TERRA ASSOCIATES, Inc.

October 10, 2023
Project No. T-8718

Subject: Response to City of Mercer Island Comments
3036 – 67th Avenue SE
Mercer Island, Washington

- References:
1. Geotechnical Report, 3036 – 67th Avenue SE, Mercer Island, Washington, Project No. T-8718, prepared by Terra Associates, Inc., dated August 22, 2022, 4th revision October 10, 2023
 3. Geotechnical Peer Review Comments, prepared by City of Mercer Island, dated September 2023

JOB NUMBER:

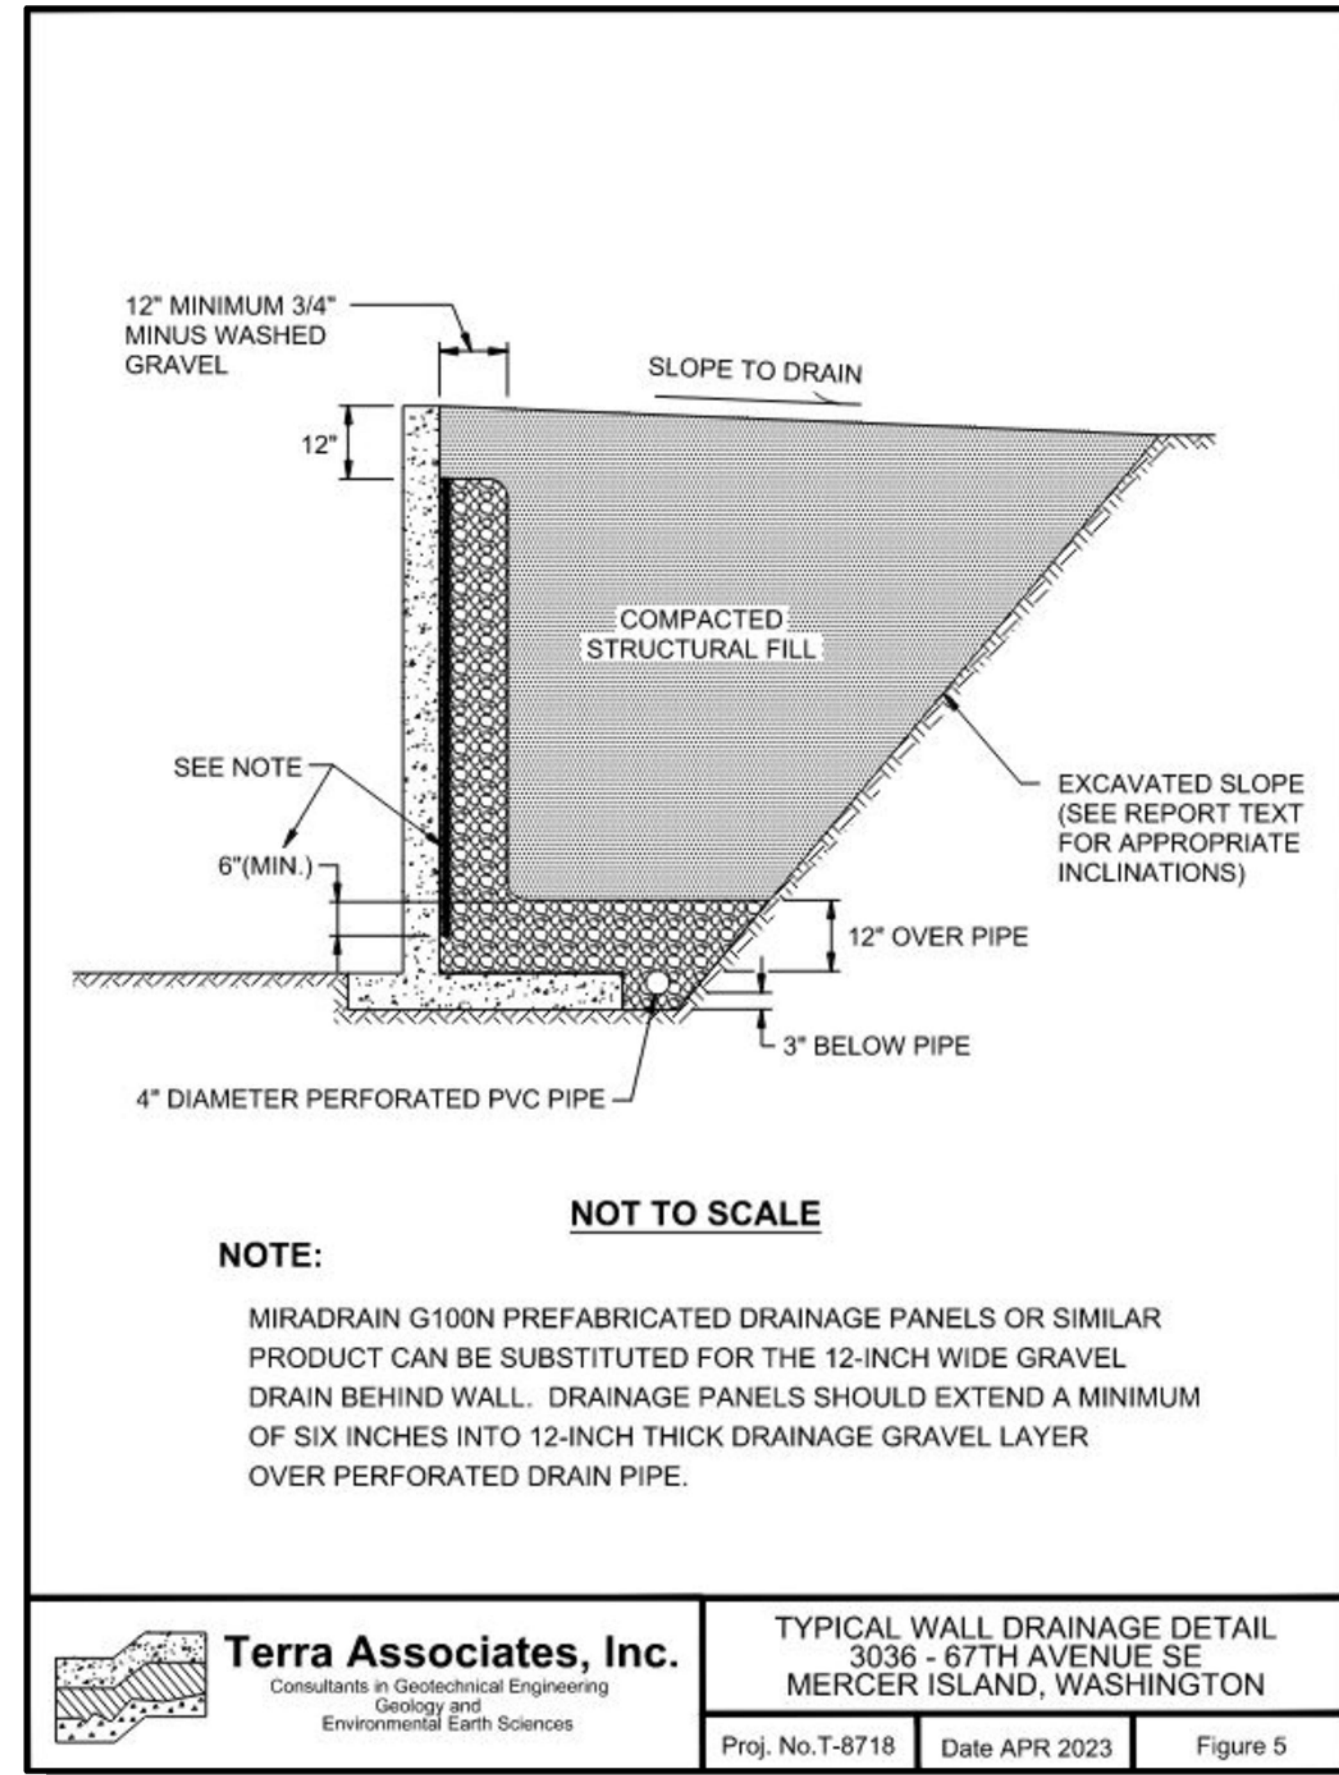
This comment was previously on the cover sheet of the SUB2 planset. It was copied here since it also pertains to the temporary excavation limits and grading shown on this plan sheet. No revisions addressing this comment were noted on this plan sheet.

Please coordinate with geotechnical engineer and review extent of proposed temporary excavations required along all property lines, easements and trees given the anticipated overexcavations below foundations.

If shoring is required to avoid encroaching on these areas (adjacent properties, easement, protected trees, etc.), please provide shoring recommendations, wall design details, calculations, etc. for review.

With no over excavation needed, there is sufficient space to complete the temporary excavation for the building.
